# Boston Alternative Energy Facility

## Statement of Common Ground between Alternative Use Boston Projects Limited and Boston Borough Council

Planning Inspectorate Reference Number: EN010095

Date: ~~February~~March 2022

DRAWING No. **PB6934-RHD-01-ZZ-DR-4021** SUITABILITY **S0** REVISION **0**

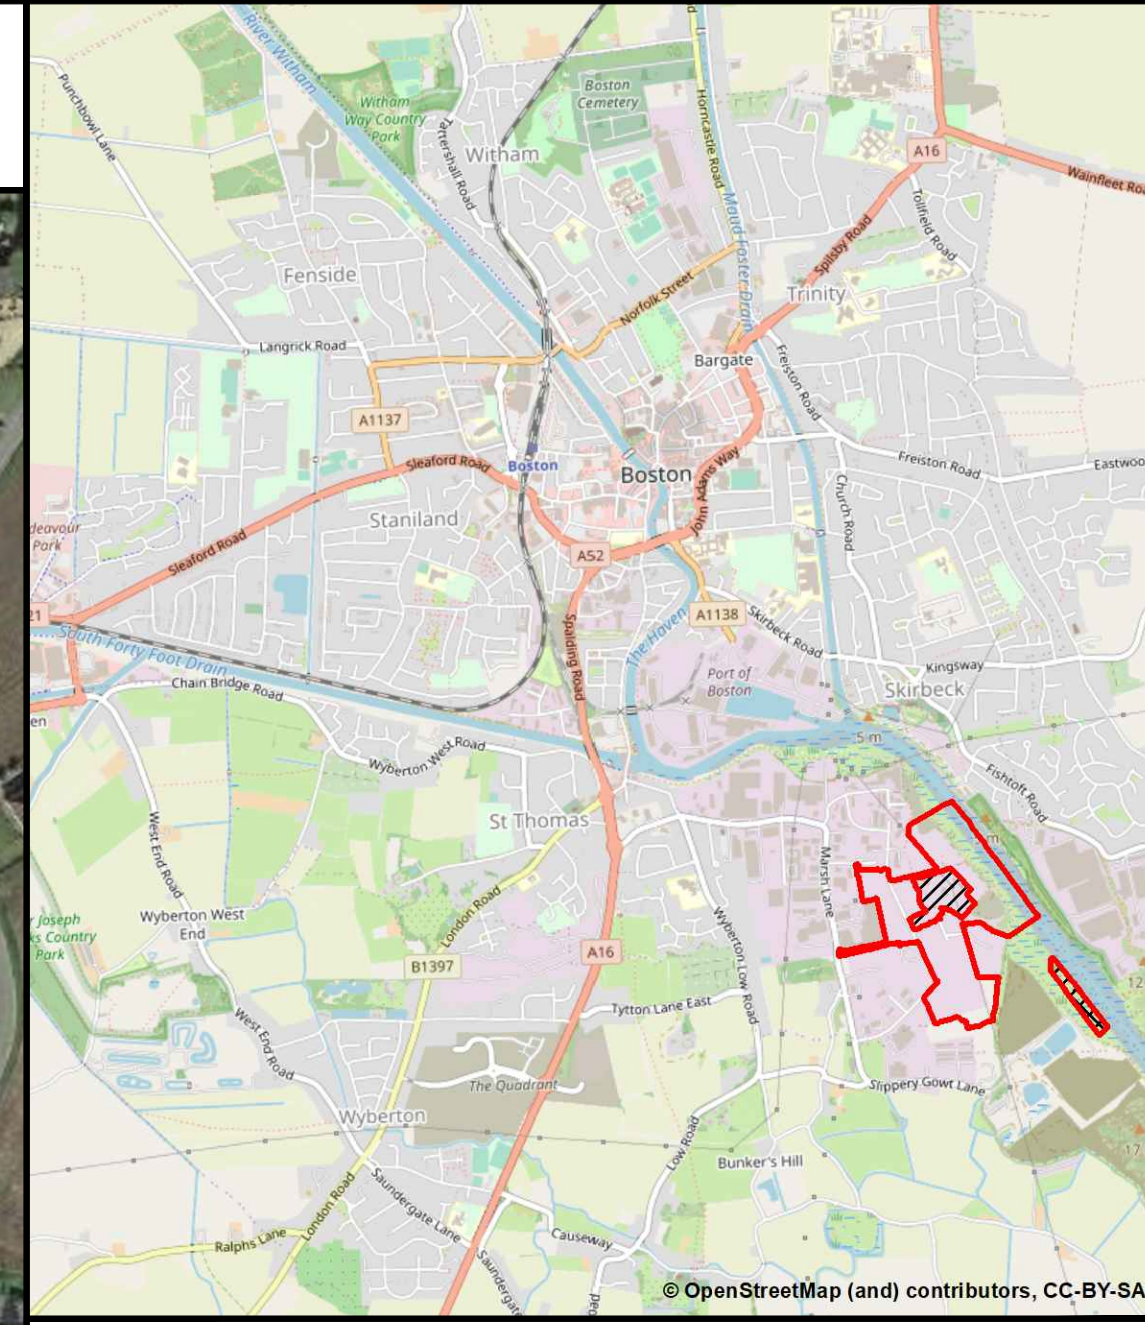
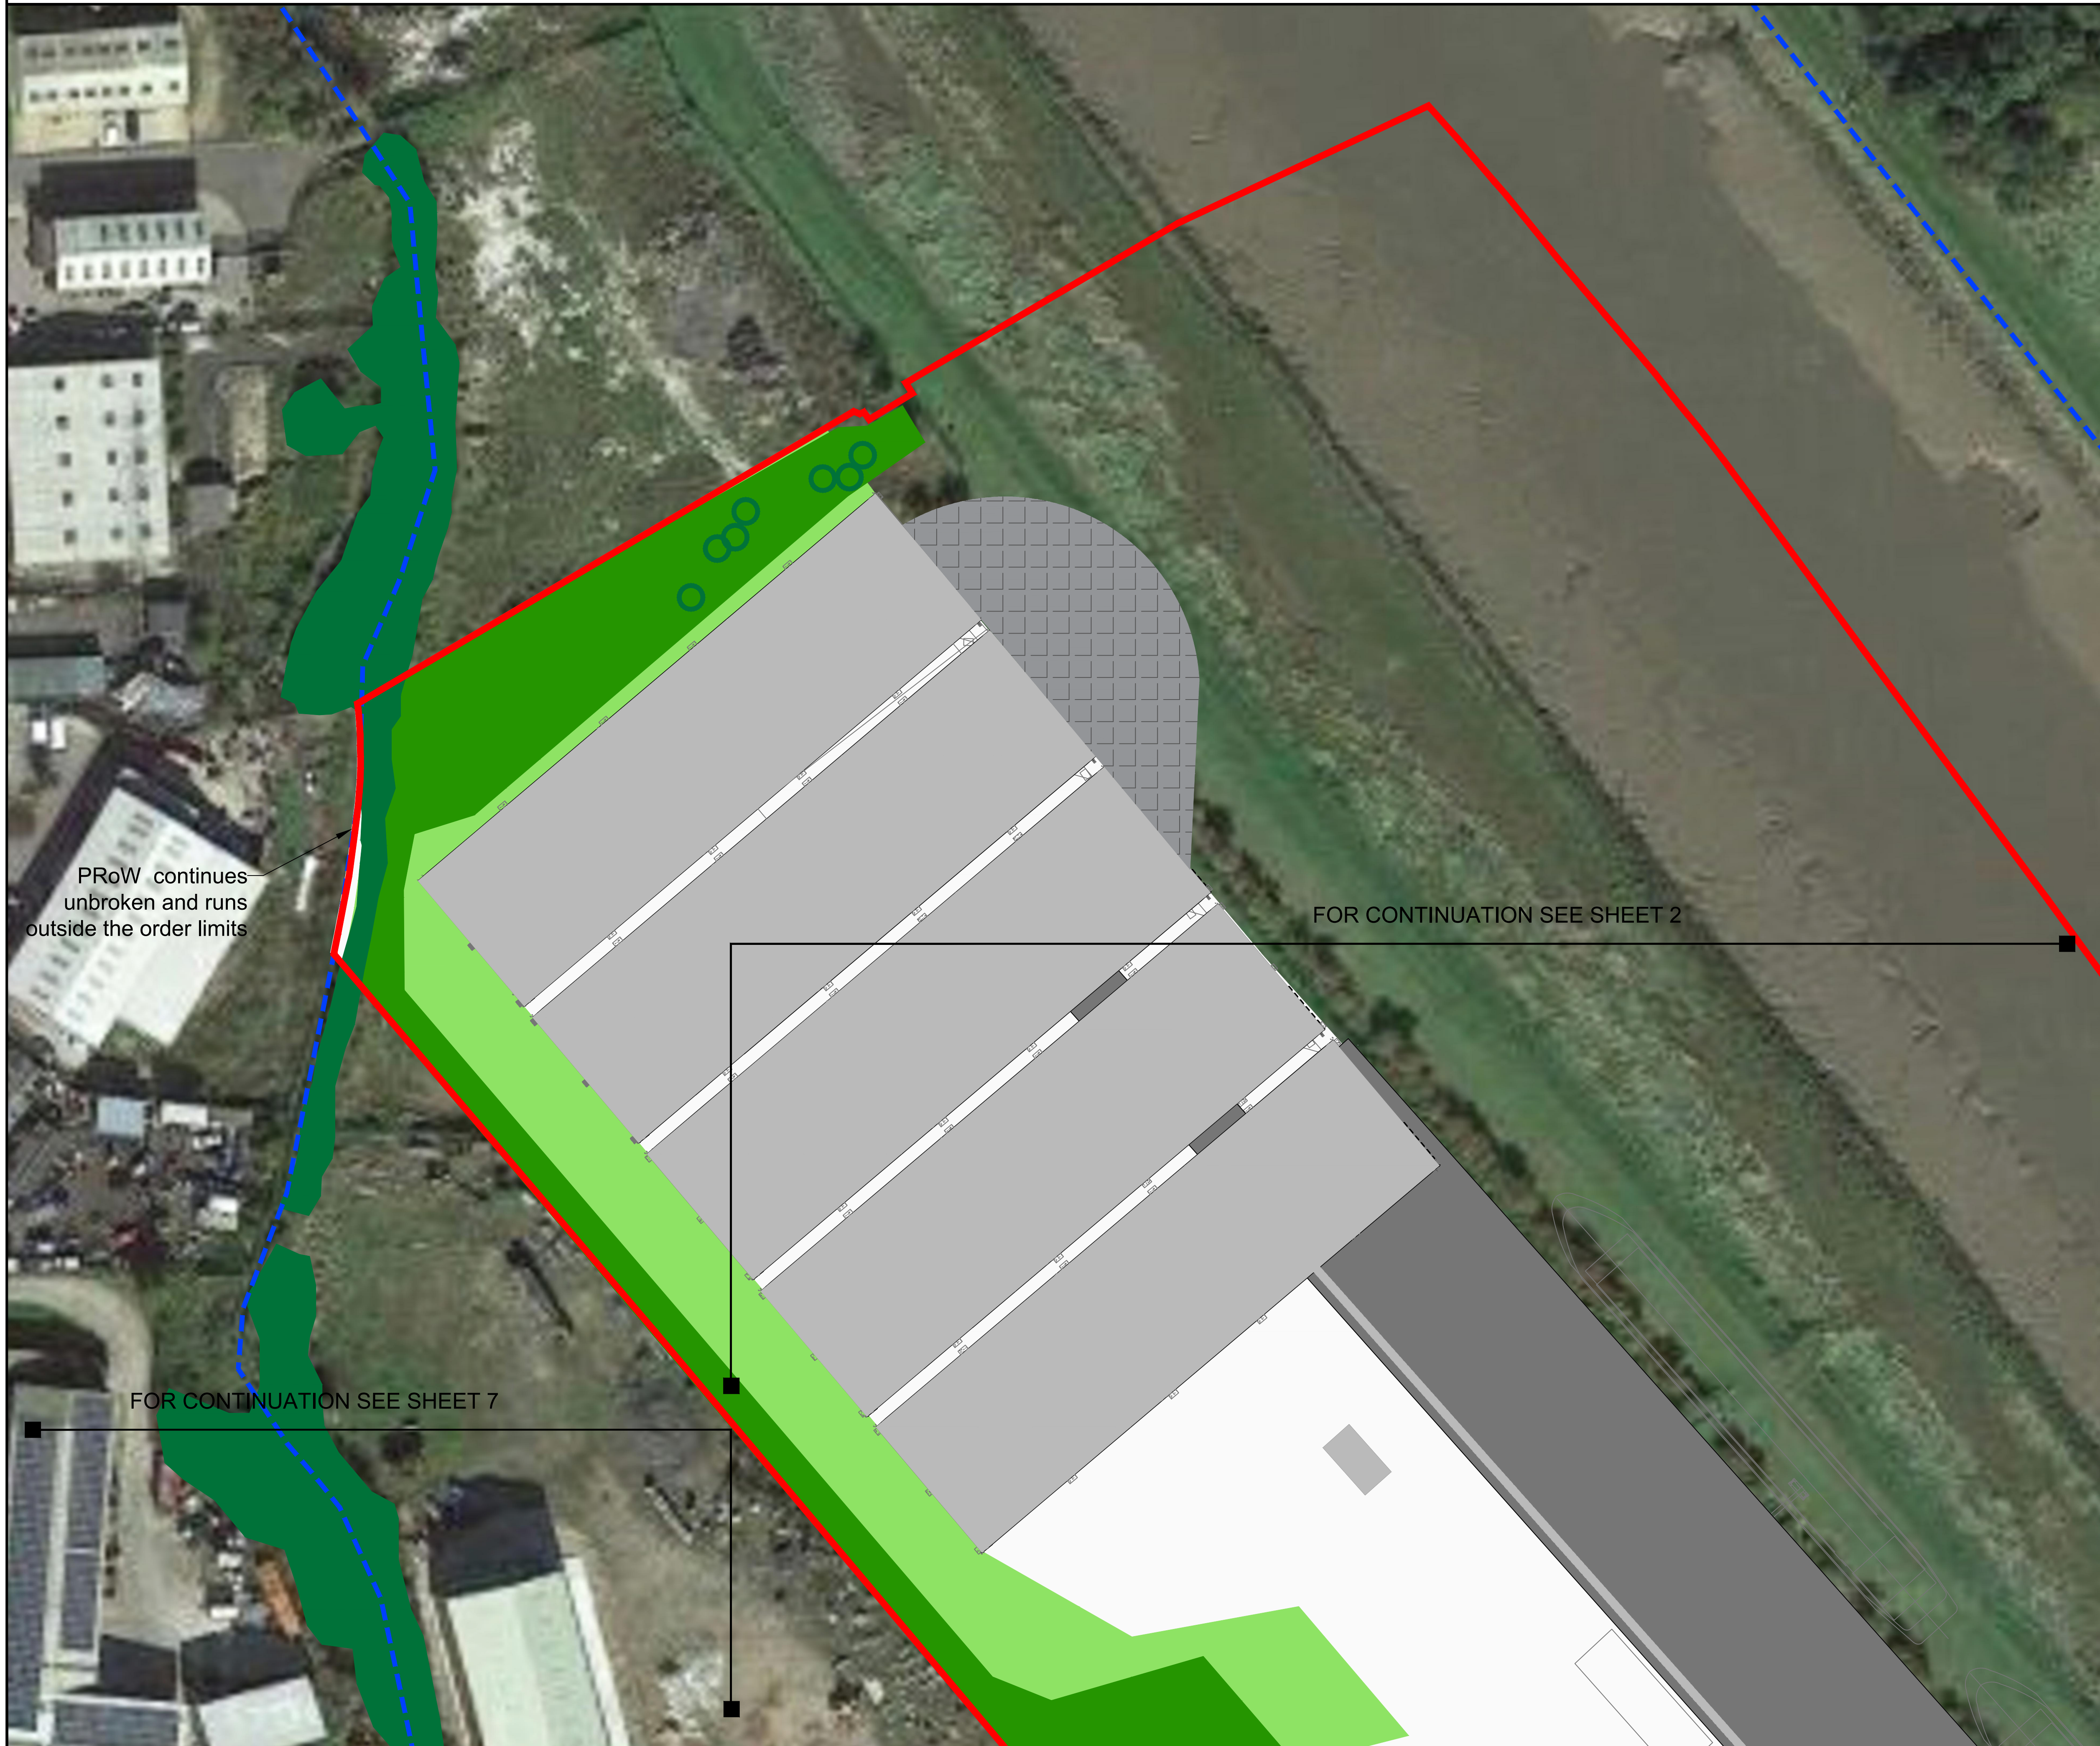
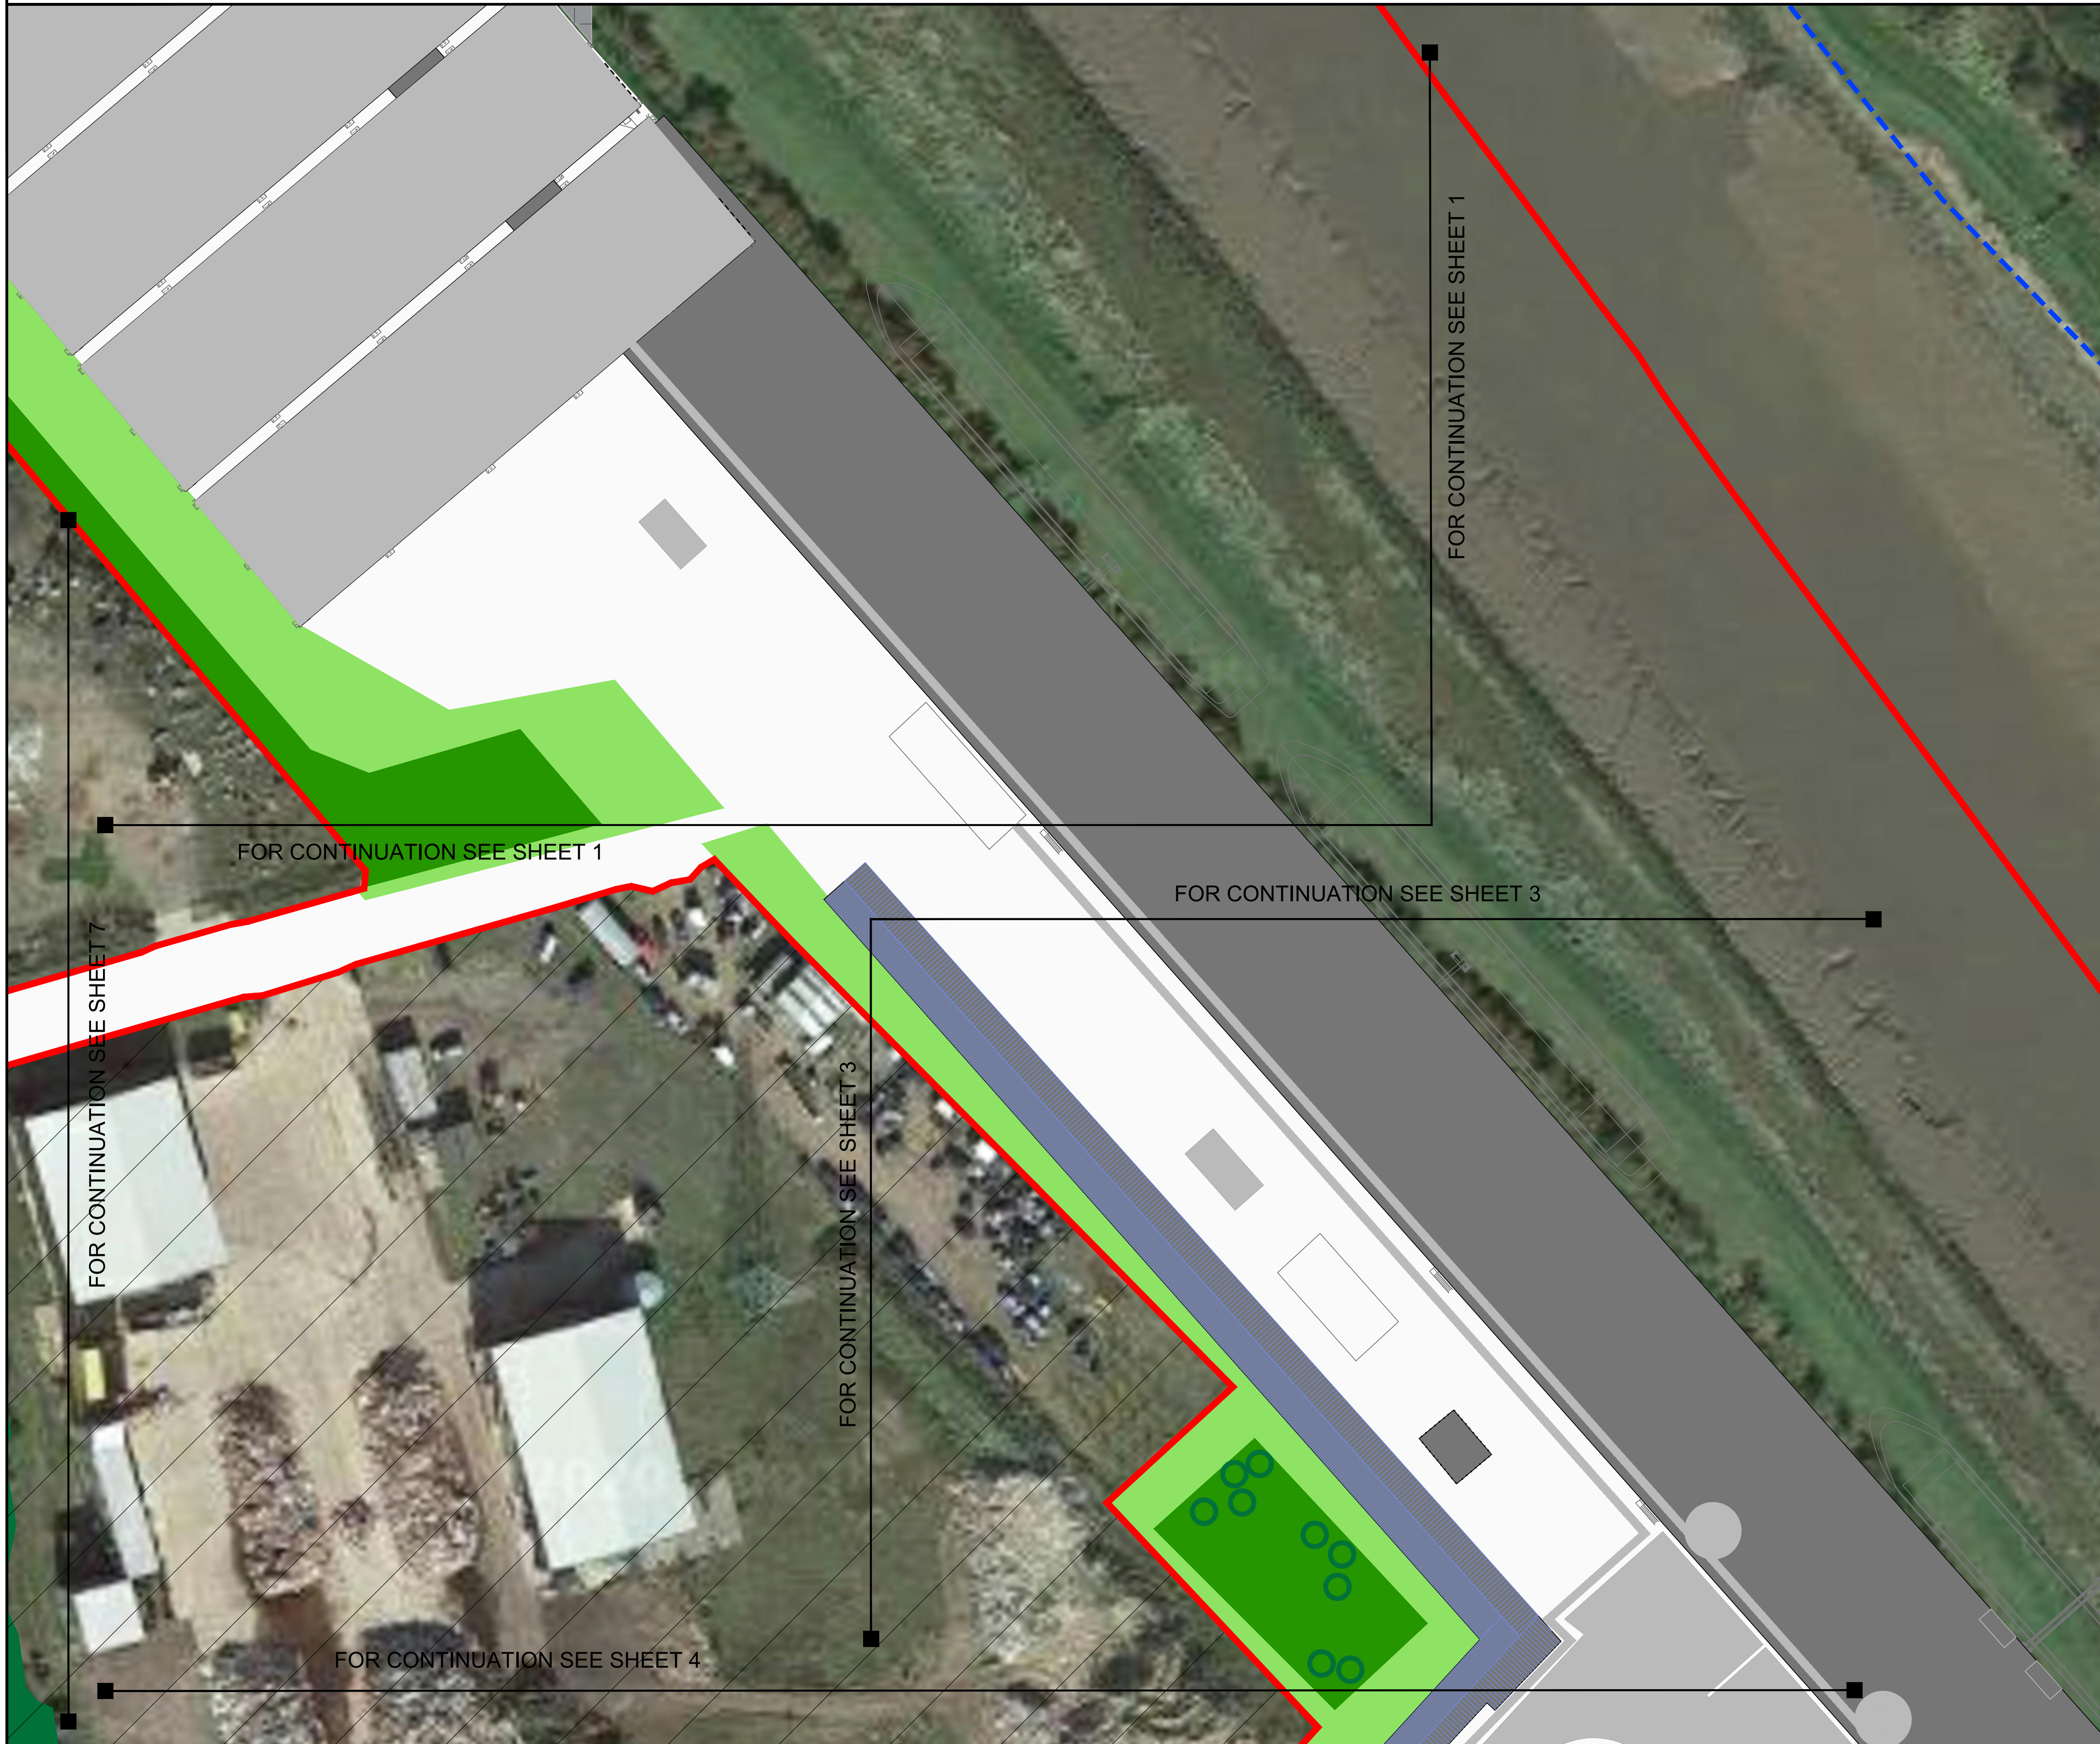
BBC 2.2	ES Chapter 9 ( <i>Landscape and Visual Impact Assessment</i> ) (doc ref 6.9.2, APP-047)	Landscape	<p>This development, as a result of its scale and form, will result in significant landscape and visual change. We note the embedded mitigation measures, but there is limited scope for other measures to reduce the impact of the structures themselves which are led by the technology proposed. We request</p>	<p>AUBP agrees with Boston Borough Council that due to the scale of the development further mitigation is not possible. However, AUBP has committed to providing interpretation of the facility (exact measures to be agreed) as part of the draft Section 106 agreement which is being discussed with Boston Borough Council <u>ad is in an</u></p>	Under discussion <u>pending conclusion of the s.106</u>

BBC 2.3	Outline Landscape and Ecological Management Plan (Doc ref 7.4, APP-123)	Biodiversity Net Gain (BNG)	<p>Further BNG opportunities should be explored at other local sites such as Woodland sites, nearby Local Wildlife Sites, Wildlife Trust sites Borough Council operated sites such as Witham Way Country Park, or in collaboration with the Eastern IFCA.</p> <p>The Council has reviewed the responses to date on this point. We note the steps taken by AUBP to</p>	<p>Terrestrial BNG is included within the Application where on-site planting is proposed. The focus on BNG is otherwise directed towards intertidal habitat loss. Therefore, the Applicant is considering BNG at Havenside Local Nature Reserve (LNR) as discussed in the updated Outline Landscape and Ecological Mitigation Strategy (OLEMS) <u>the latest version was submitted at Deadline 7</u> (document reference 7.4(24),</p>	<p>Under discussion <u>pending conclusion of s.106</u></p>

SoCG Reference	Document Reference	Topic	BBC's Position	AUBP's Position	Status
			undertaken in accordance with BS5837 standards, and that in the event trees are required to be felled or removed, appropriate mitigation planting should be provided.	under Requirement 6 of the draft DCO (document reference 2.1(42), REP83-0043). An <u>updated version of the</u> Outline Landscape and Ecological Mitigation Strategy (document reference 7.4(2), APP-123REP7-037) was submitted with the application at Deadline 7, which details the proposed procedures in relation to site clearance and proposed planting. The Illustrative Landscape Plans (document reference 4.4, APP-014) show the locations of proposed planting.
